Wilmington Arundel Road Angmering BN16 4ET.

I have reviewed the approval of details reserved by condition imposed under A/44/24/PL relating to condition 3 - Biodiversity Enhancement Layout.

Project	Gatehouse, Angmering	Date	Oct 2025	Drawing No.	CSA/6521/102
Drawing Title	Ecological Enhancements Plan	Scale	Refer to scale	Rev	A
Client	JW Stratton	Drawn	JR	Checked	JR

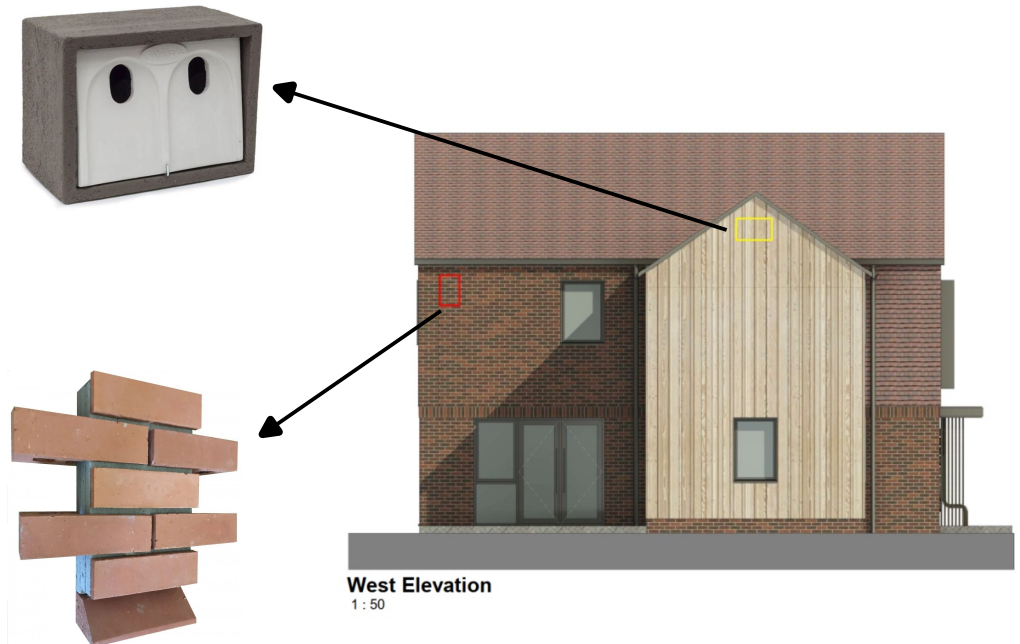
I Please see the below response from our ecologist. We require further information concerning the enhancement opportunities. I would suggest including a bat box to the west elevation, hedgehog holes in fences and a log pile.

The Biodiversity enhancement layout has one sparrow terrace identified. None of the other ecological enhancements set out in the Preliminary Ecological Appraisal CSE/6521/01 (May 2023) have been included. These are listed below.
